MERITON

9 June 2009

MP 09_0033: 3-5 PYMBLE AVENUE, PYMBLE

Balcony locations and screening

DRAWING TITLE:
E LEVEL 01 - ARCH 100

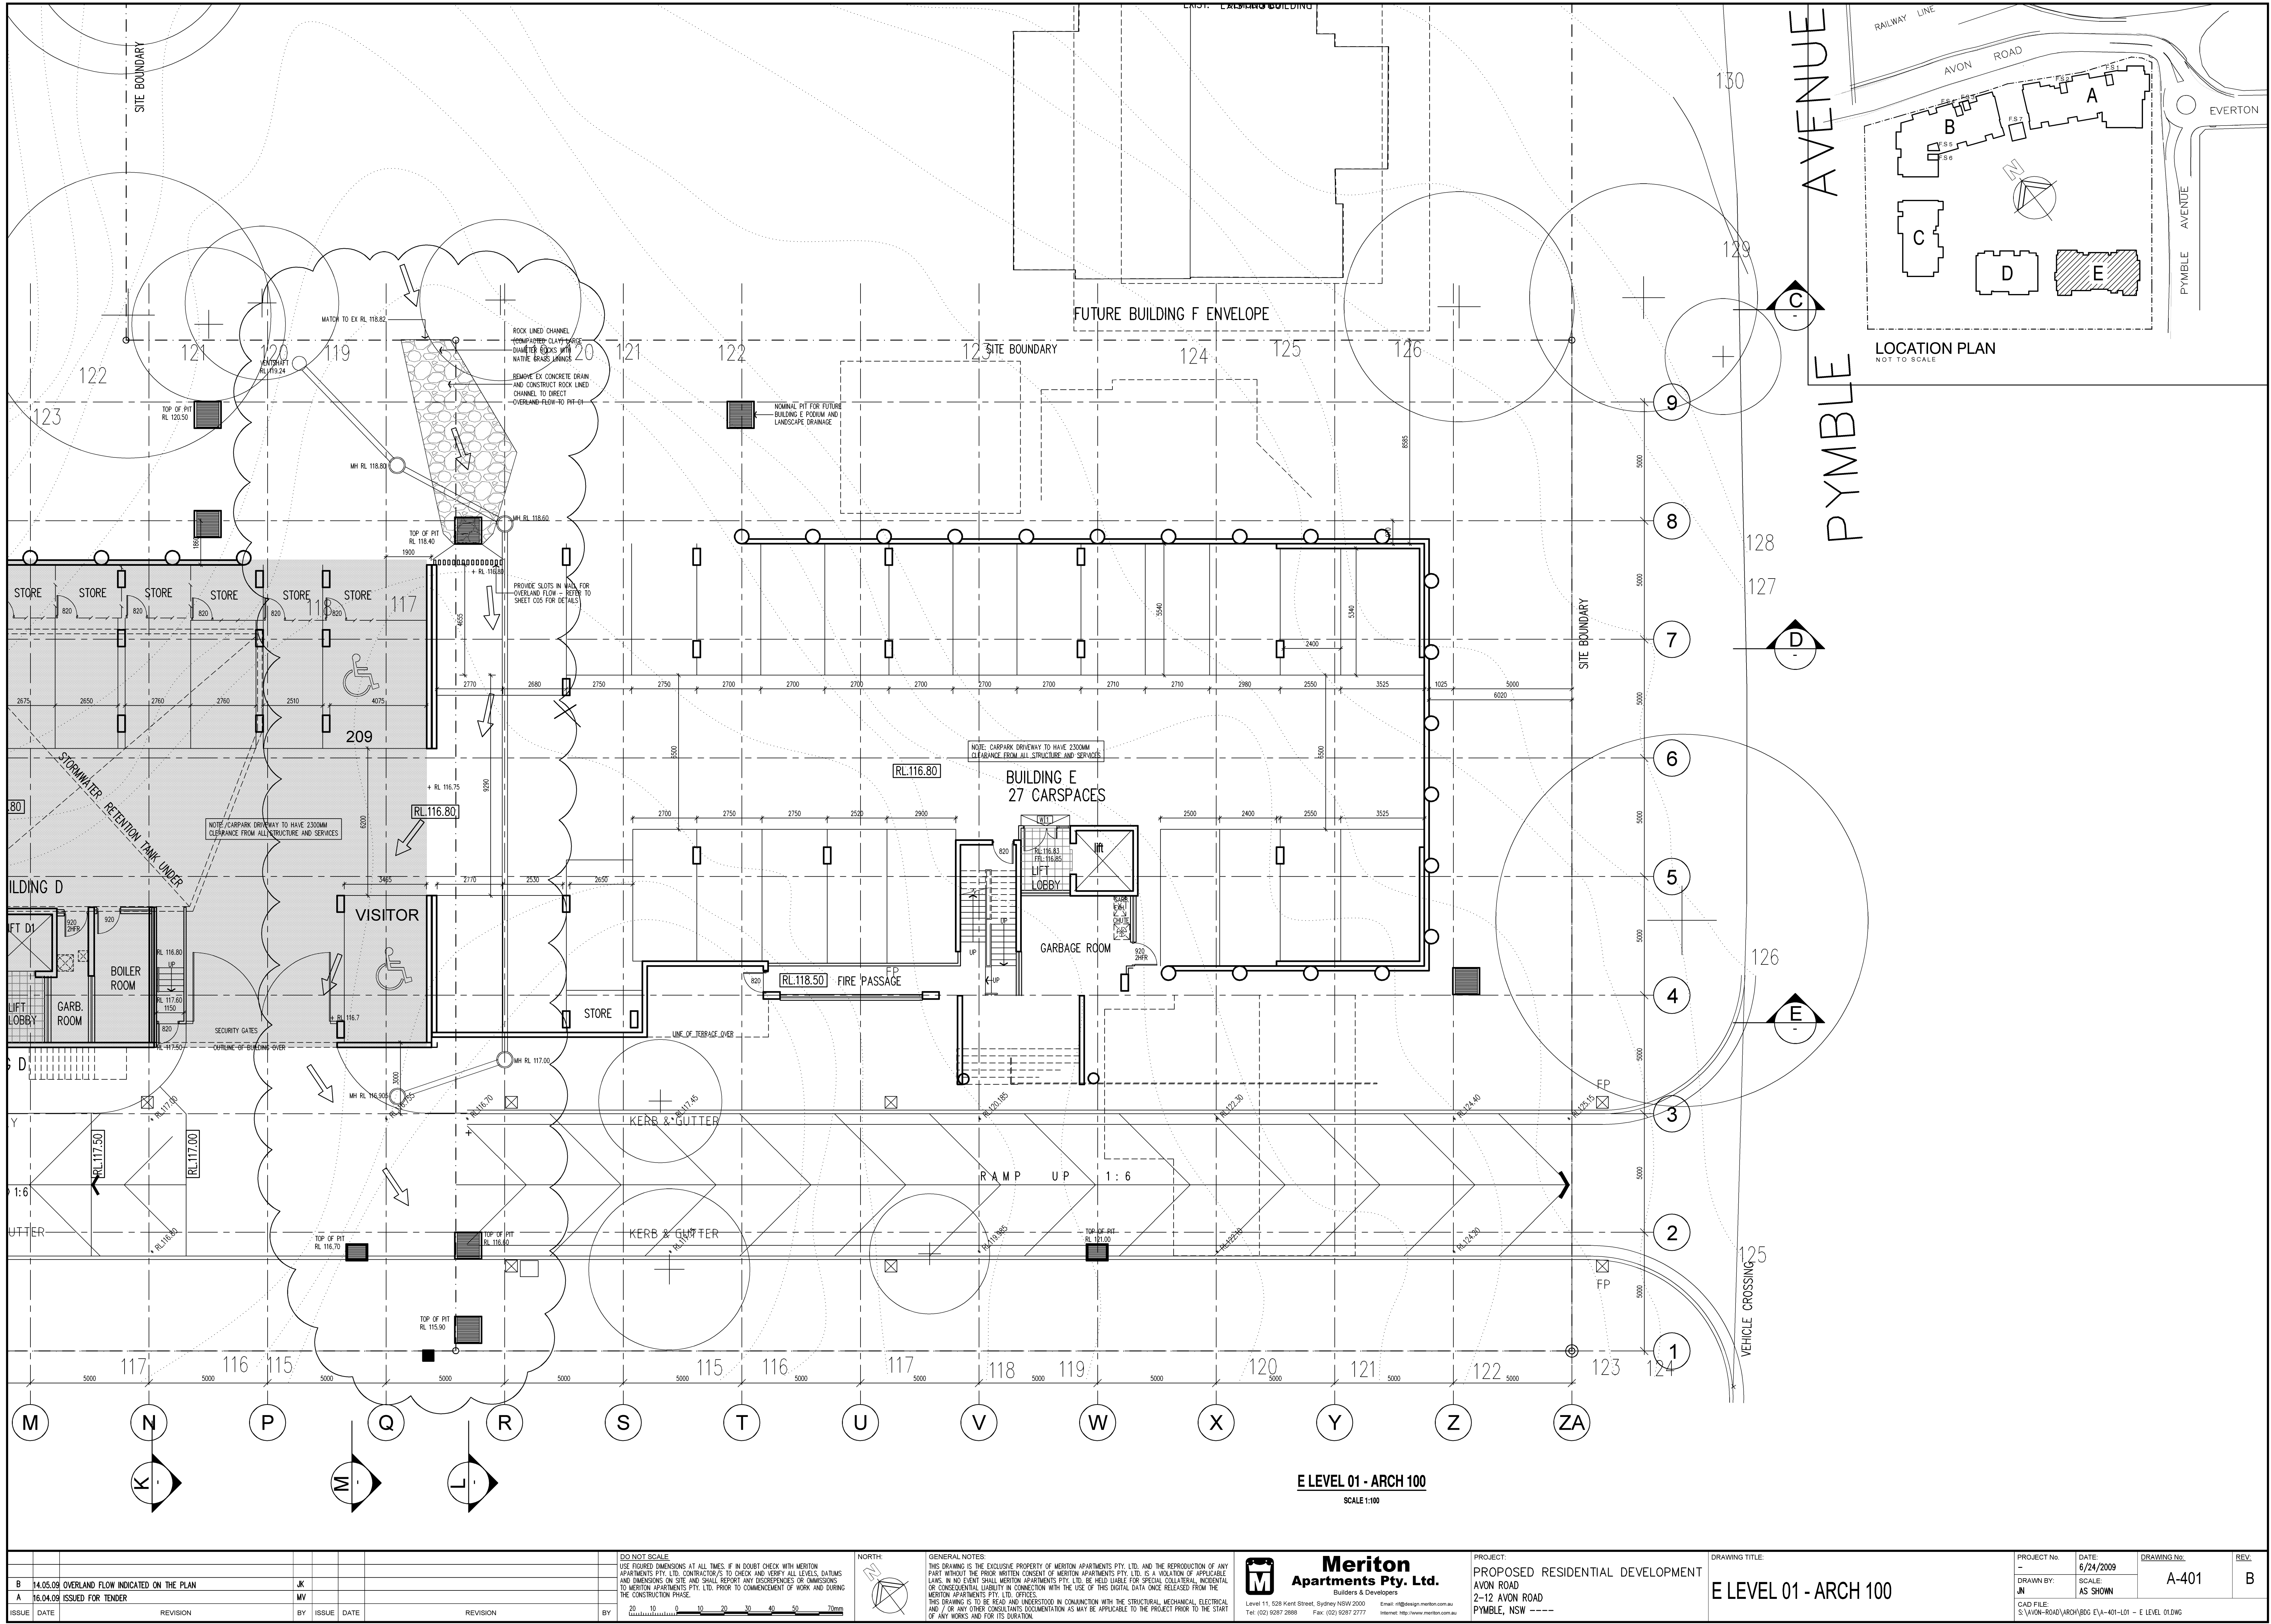
Enclosed is a site plan that shows the location of proposed Building E and how it relates to the existing dwellings at 1 and 1A Pymble Avenue. The plan clearly shows that proposed Building E has adequate separation from the adjoining dwelling houses. The proposed landscape screening is also illustrated on the site plan, which shows a substantial buffer between Building E and the properties of 1 and 1A Pymble Avenue.

DRAWING TITLE:
E LEVEL 02 - ARCH 100

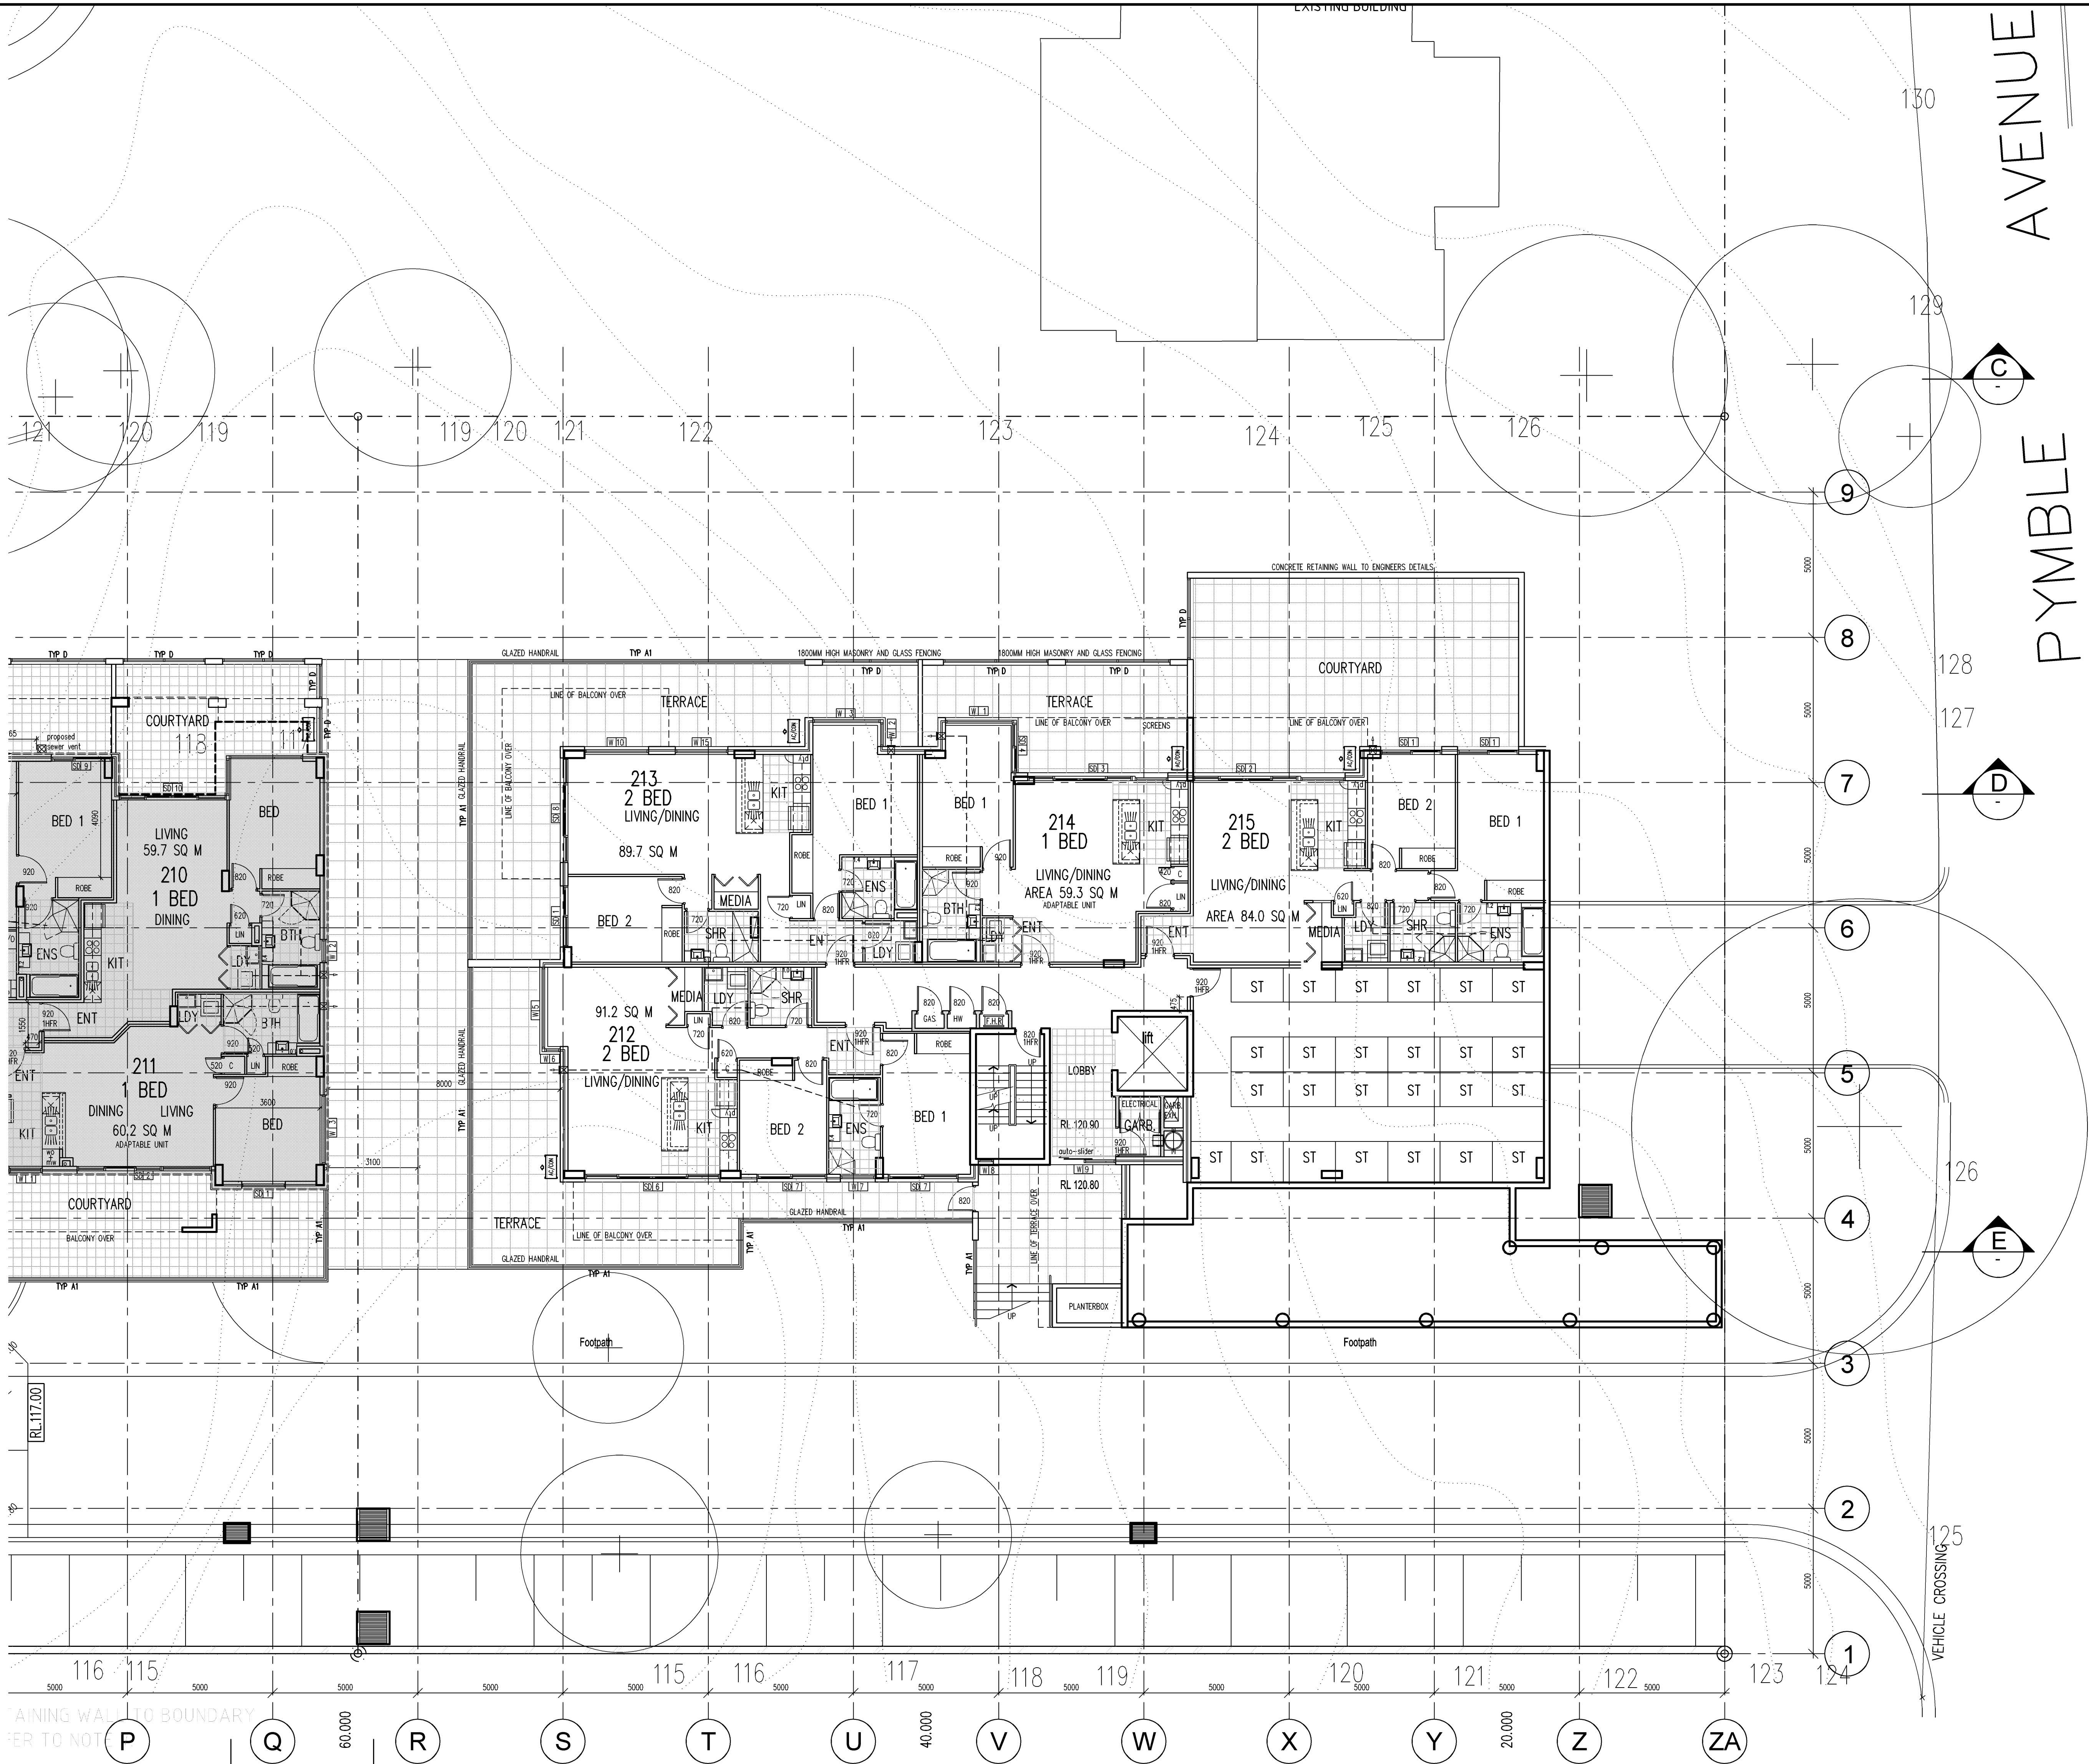
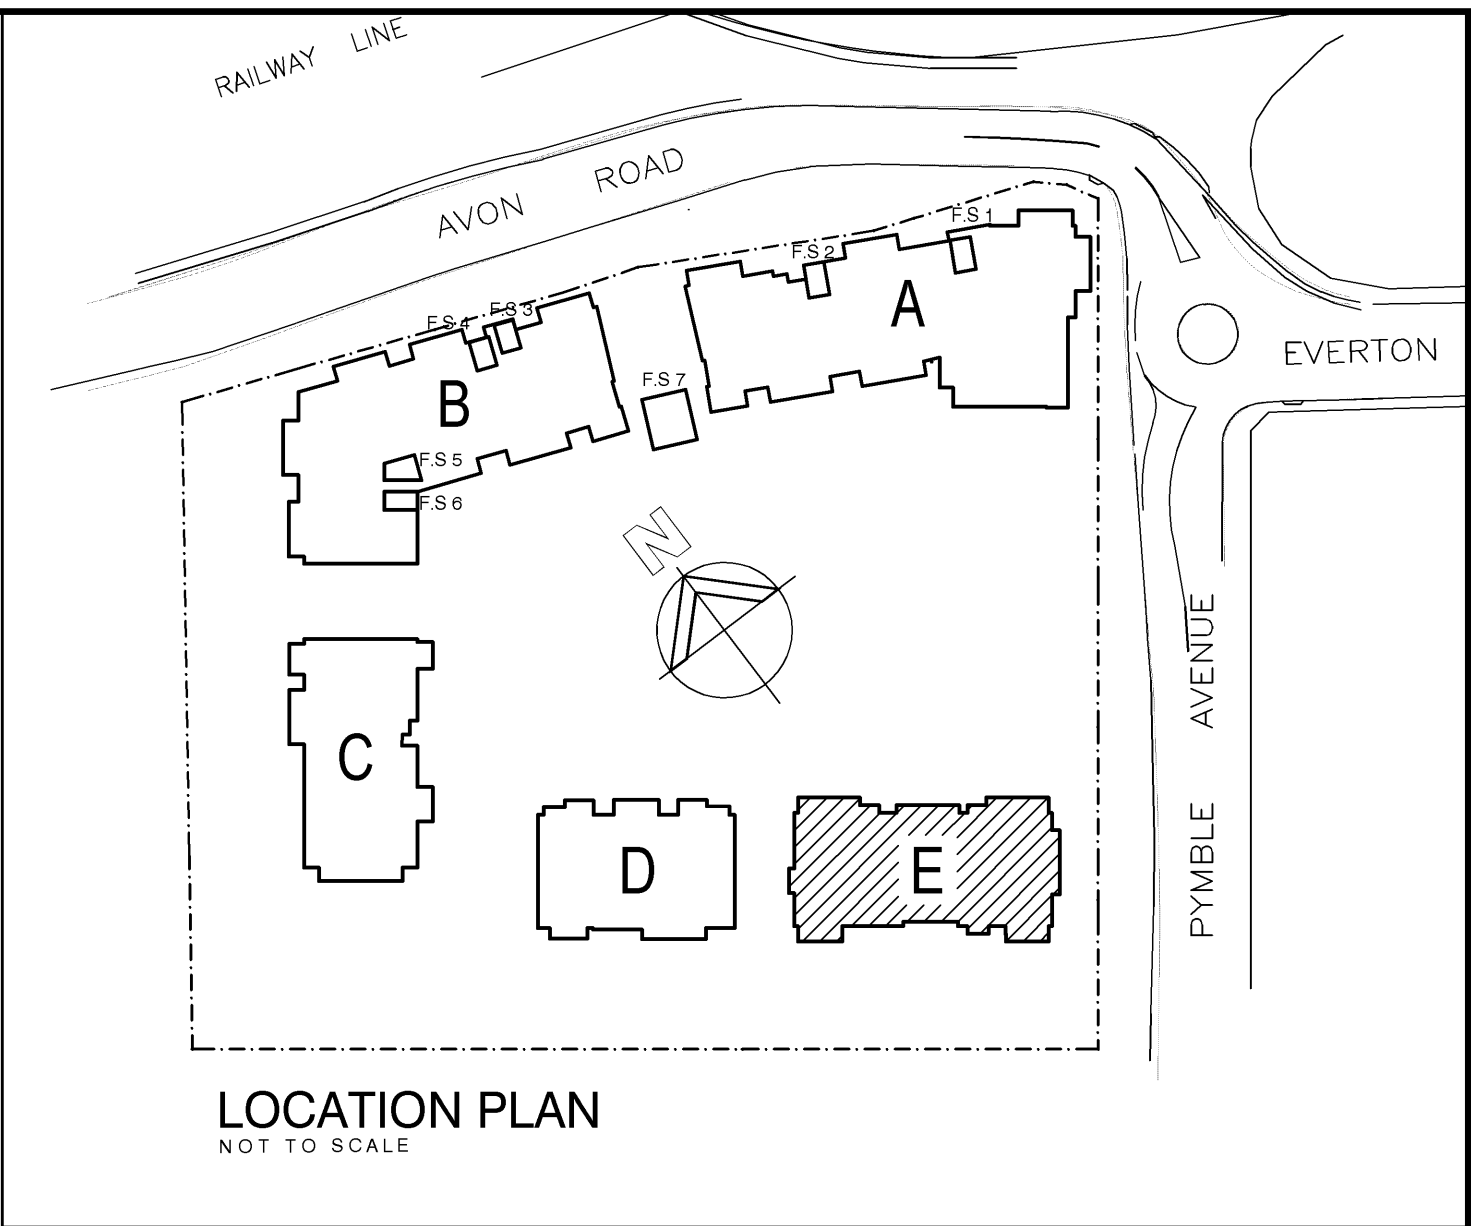
- **Level 2:** In Unit 213, the sliding doors from the living room to the terrace have been relocated from the northern side to the western side. This will focus the activity of this unit away from the adjoining dwelling house.

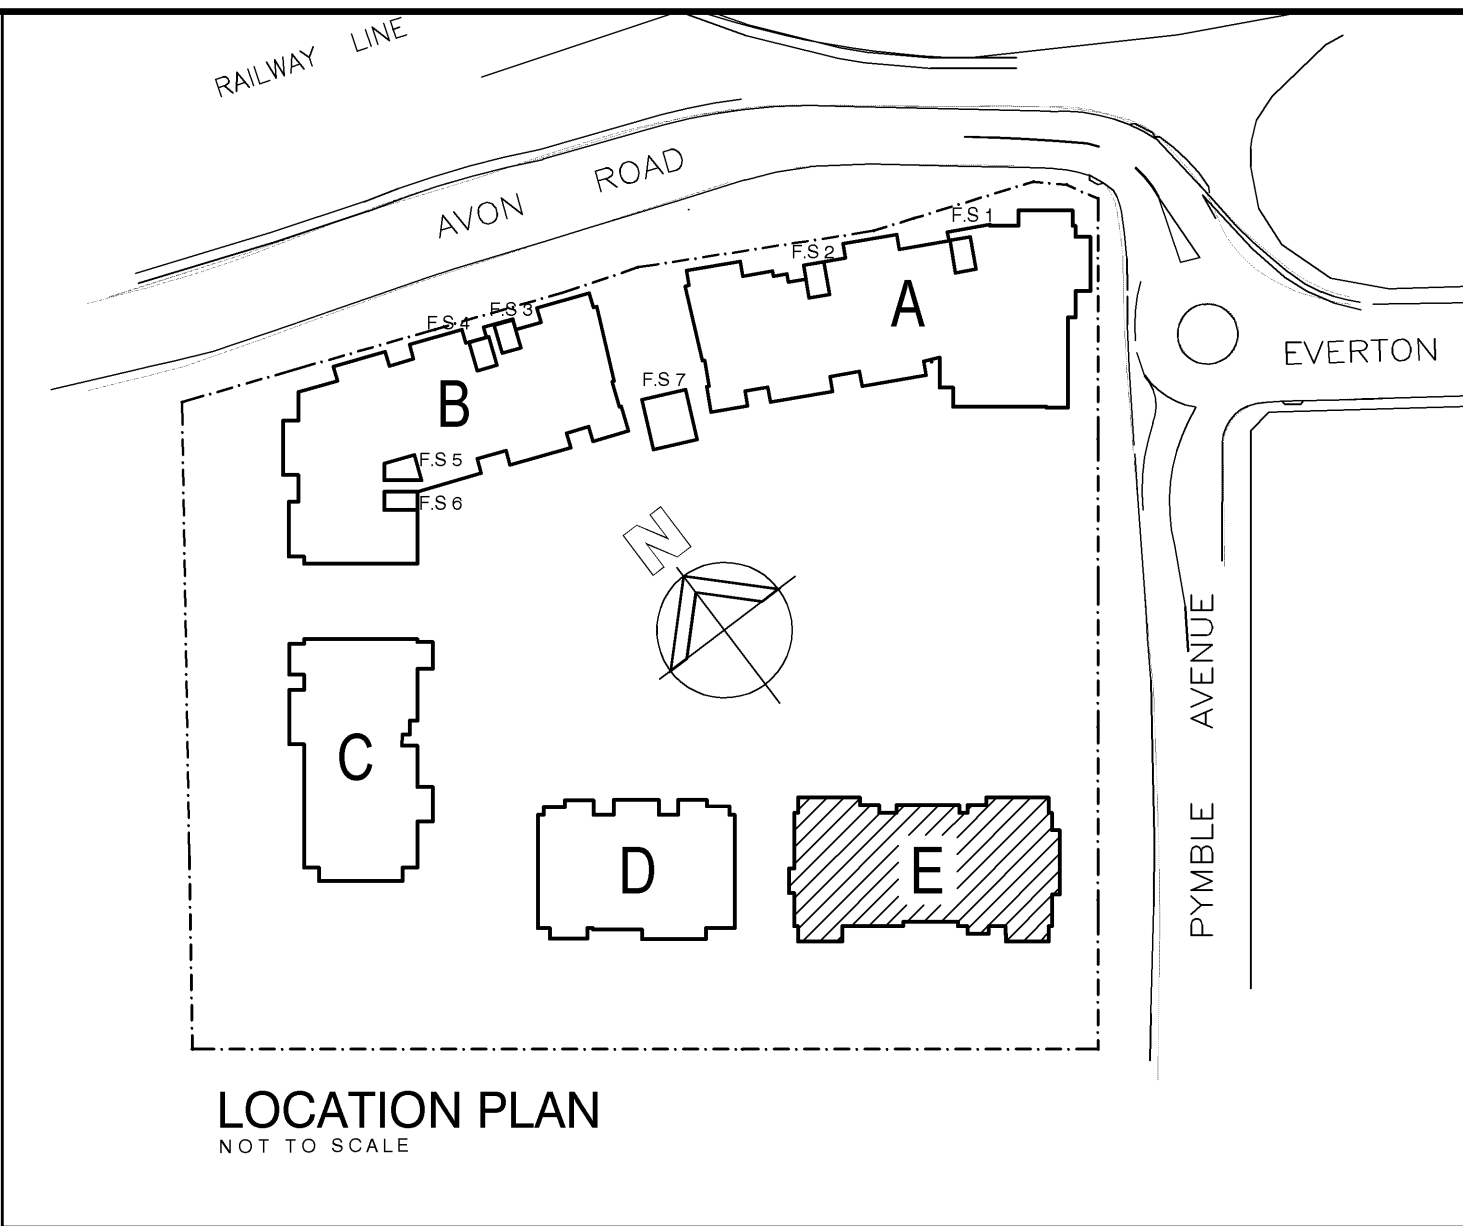
- **Levels 3-5:** The balcony to Units 313, 413 and 513 have been repositioned so that their primary orientation is northwest, away from the adjoining dwelling houses. The northern balustrade of those balconies has also been fitted with obscure glazing to further minimise overlooking.
- **Level 6:** At Unit 613, the balustrade has been 'pulled back' from the northern edge of the building to reduce overlooking opportunities. Sliding screens are also proposed along the northern part of the balcony to further minimise overlooking.
- **Level 7:** At Unit 712, the terrace has been reduced so that it no longer continues along the northern side of the unit.
- **Elevations:** The north, south and west elevations have been amended to reflect the changes to the floorplans described above.
